**City of Portland, Maine - Building or Use Permit Application**

**Proposed Project Description:**  
Amendment to permit #050728 Change footprint from flat roof to pitched roof

<b>Proposed Use:</b> Doctors Office/ addition to existing bldg	<b>Proposed Project Description:</b> addition to existing bldg
---	---

Floor Framing @ 1375 Congress (Bedix Corner Condolment) 1/2" = 1' APPROX

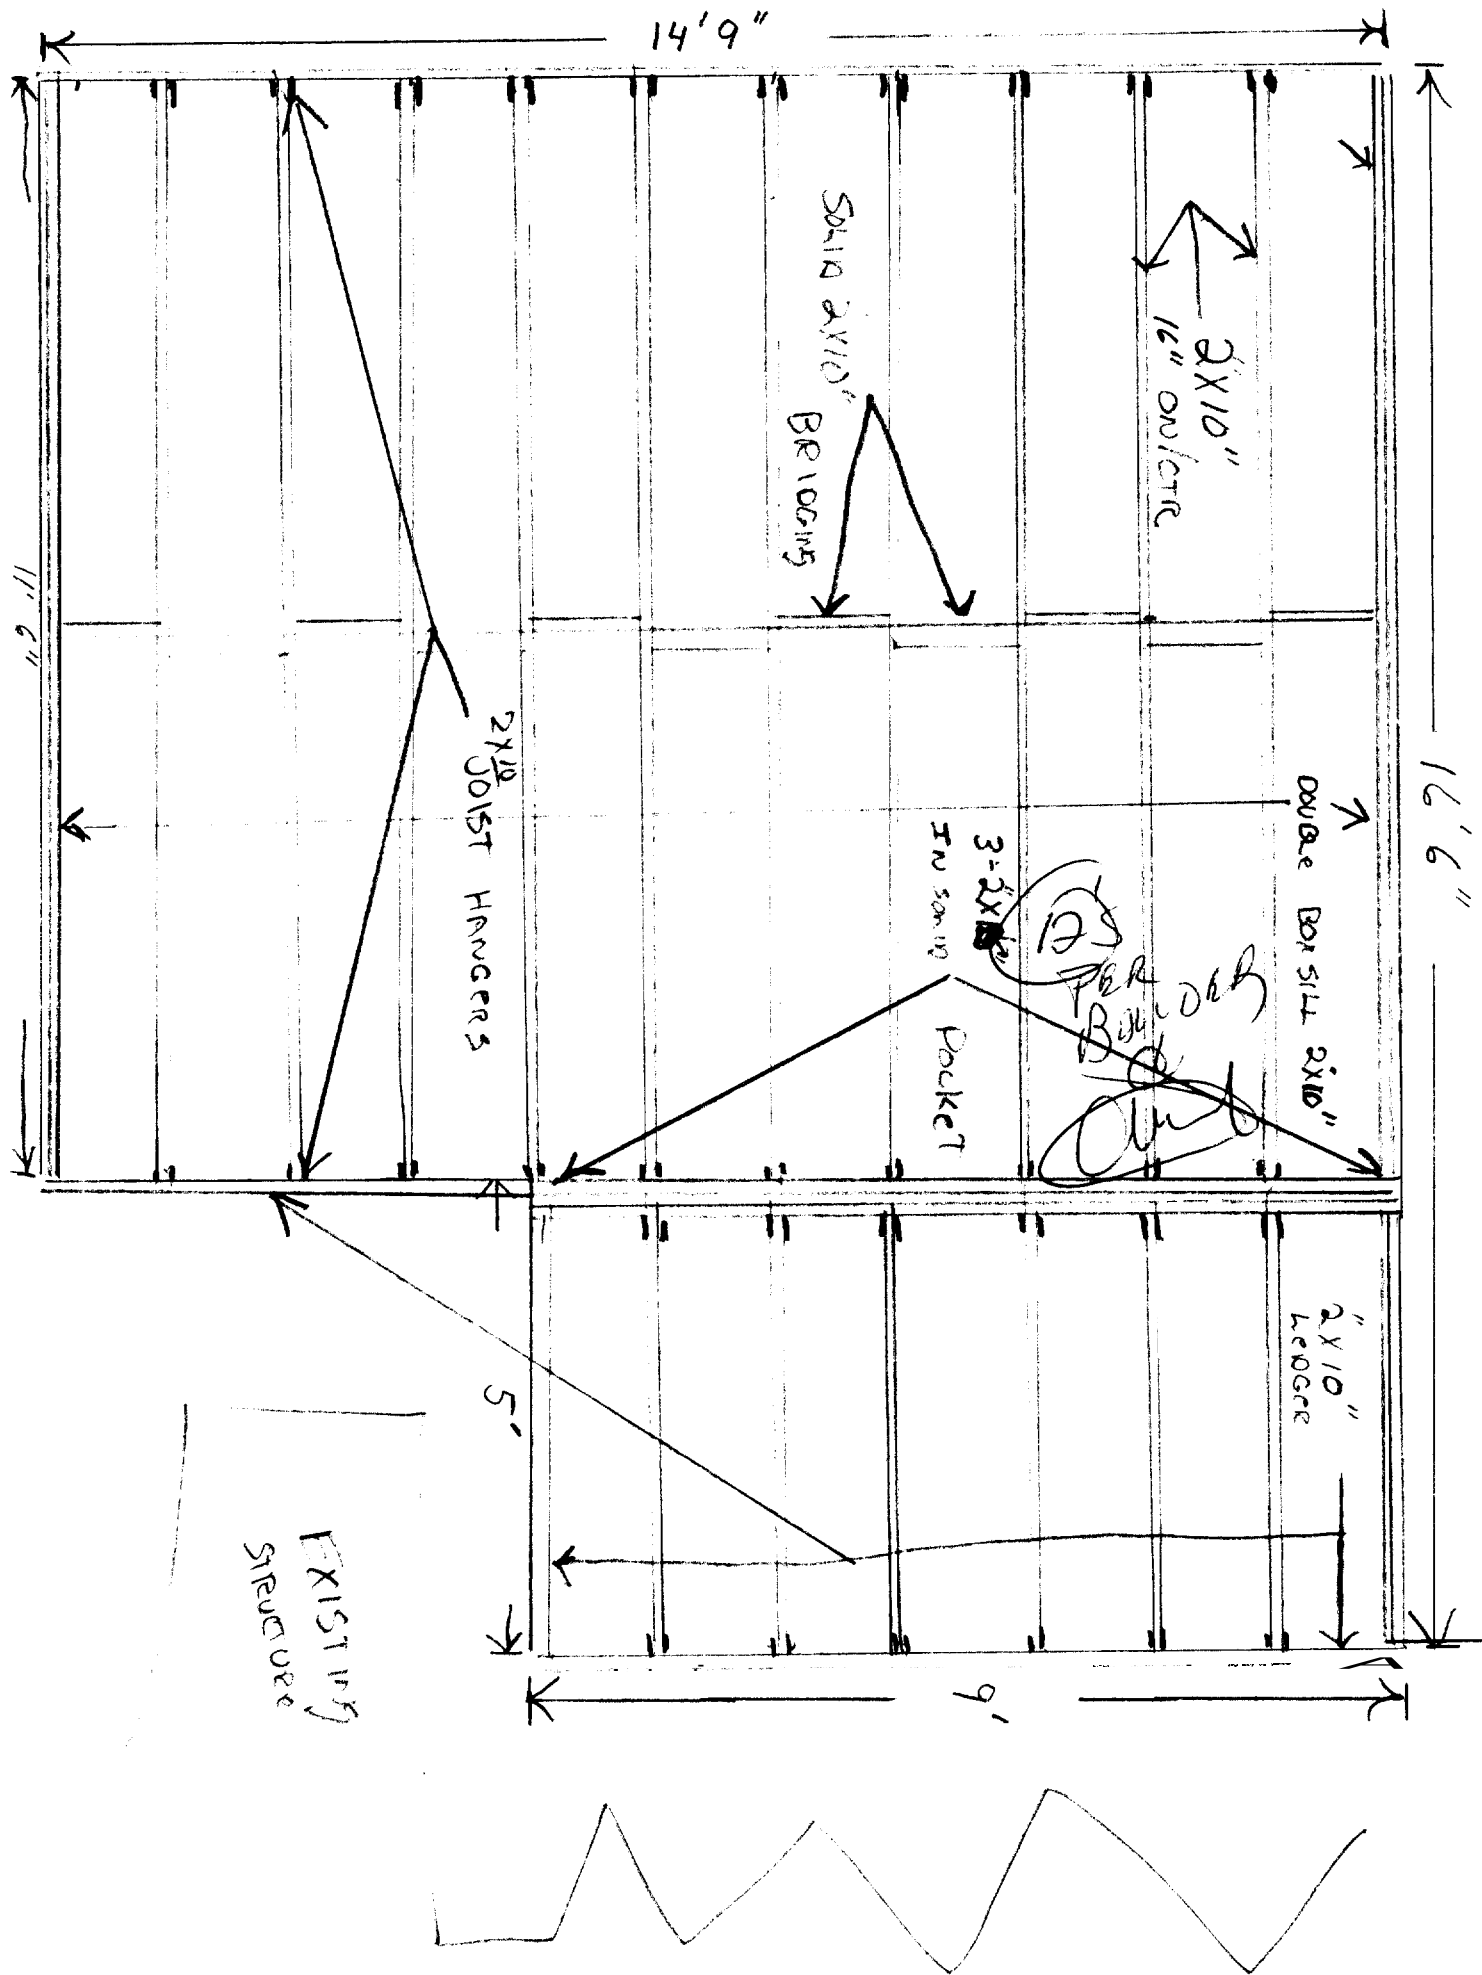
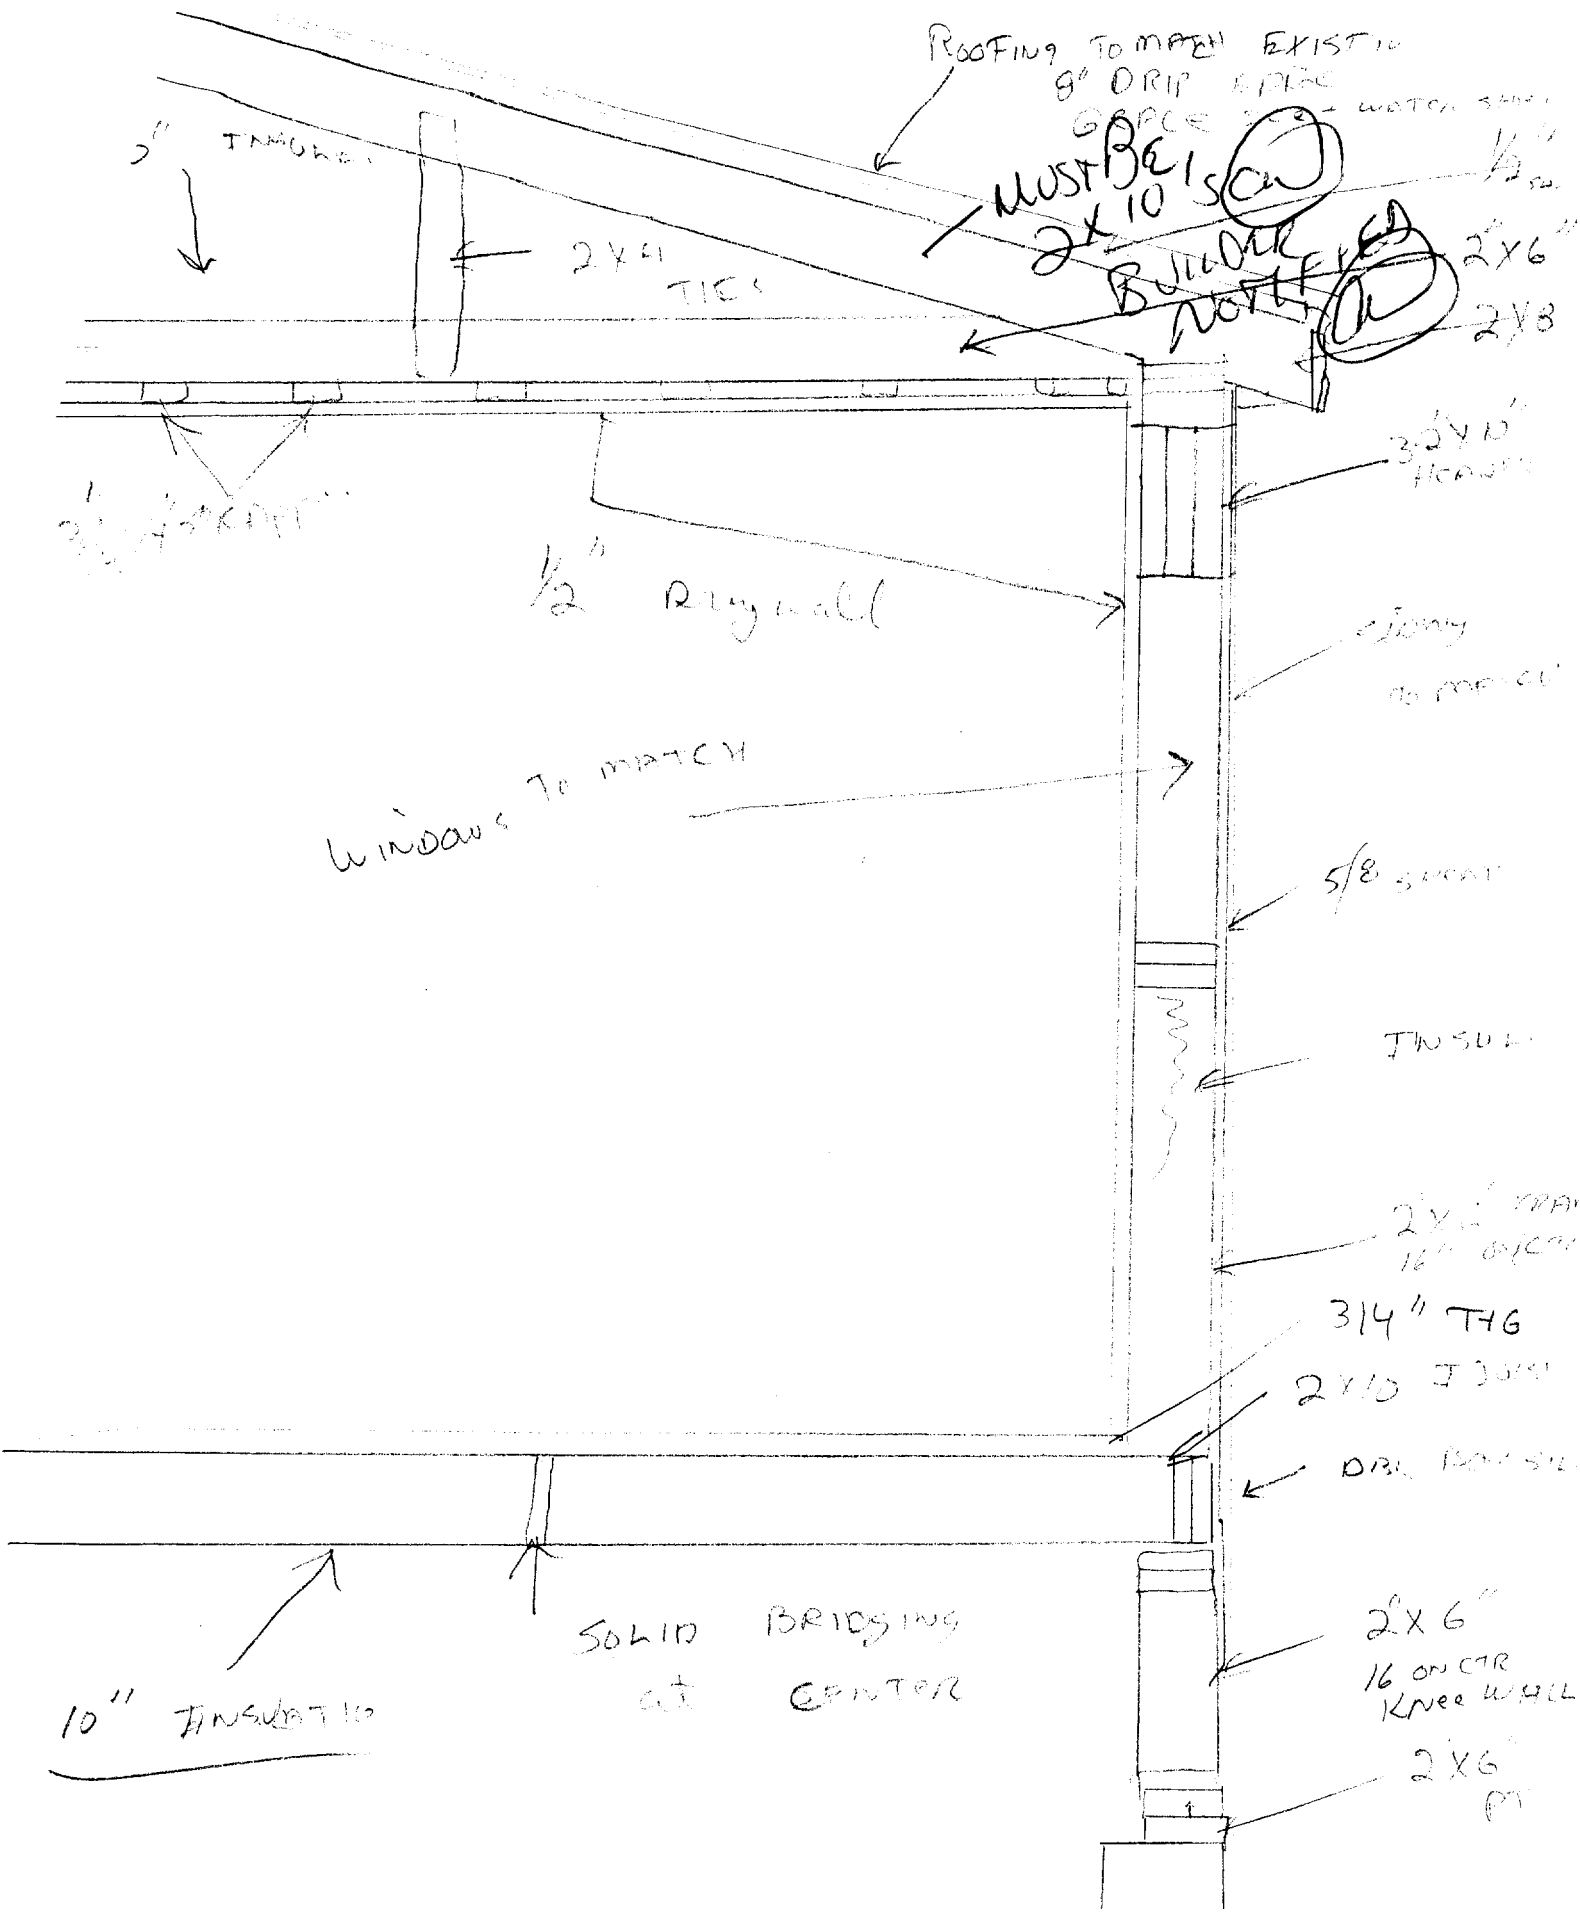
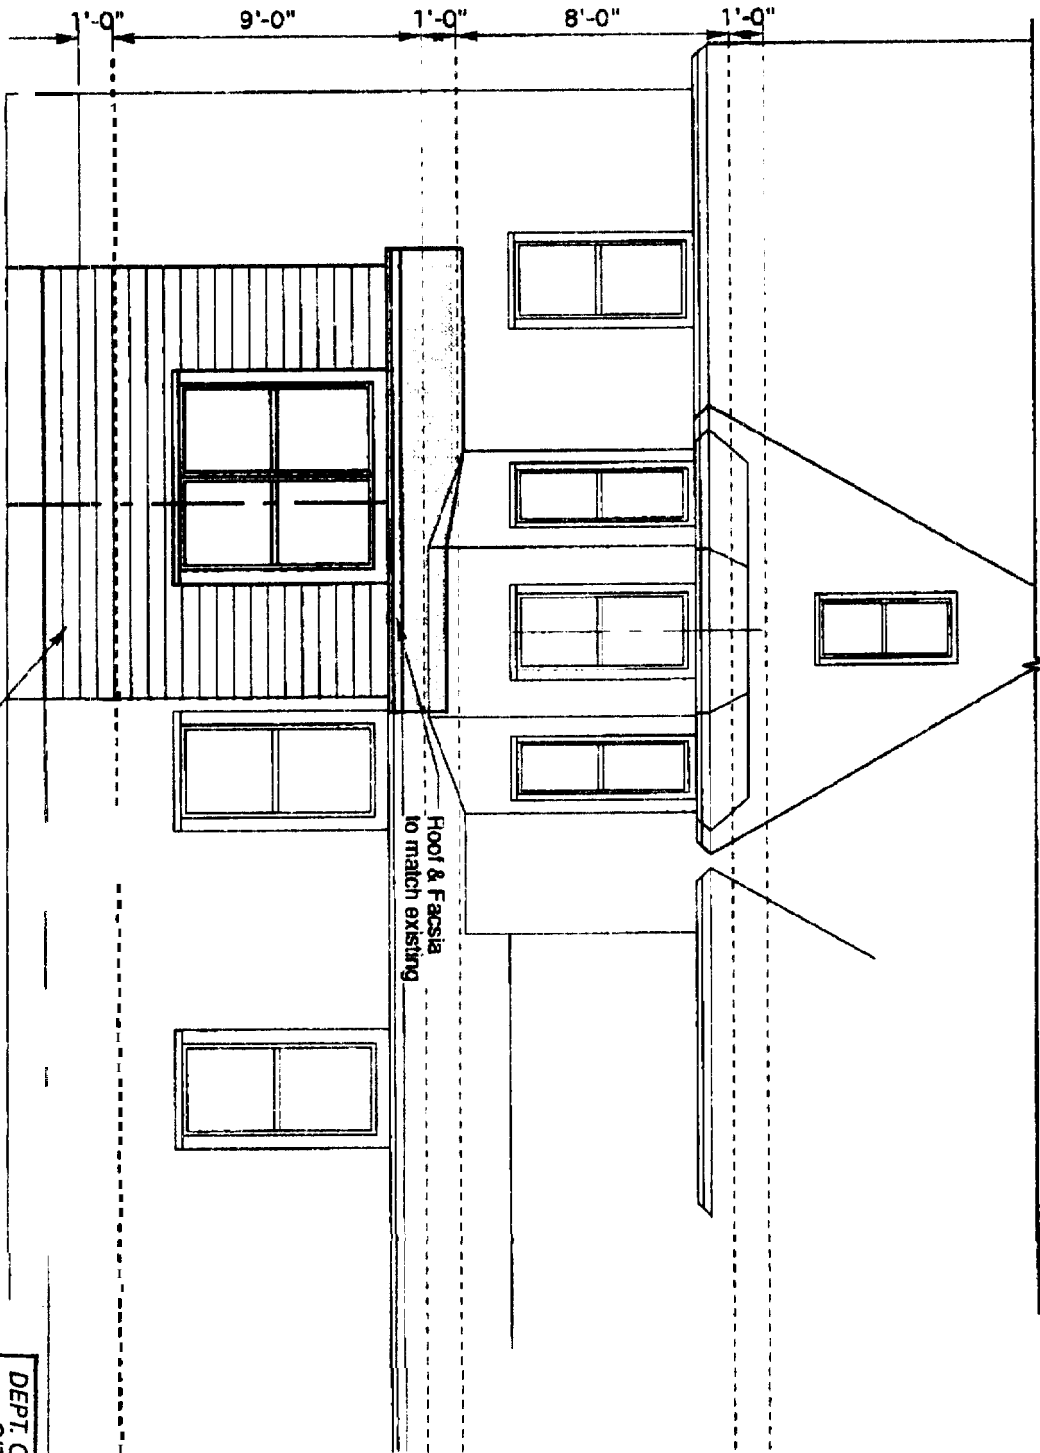
**Comments:**  
7/15/2005-mjn: need framing details...better structurals  
8/3/2005-ldobson: Dropped off better structurals LJD  
8/3/2005-mjn: Shows 2" x 8" for rafters spanning 14'9" .....UNDER DESIGNED.....contractor notified.
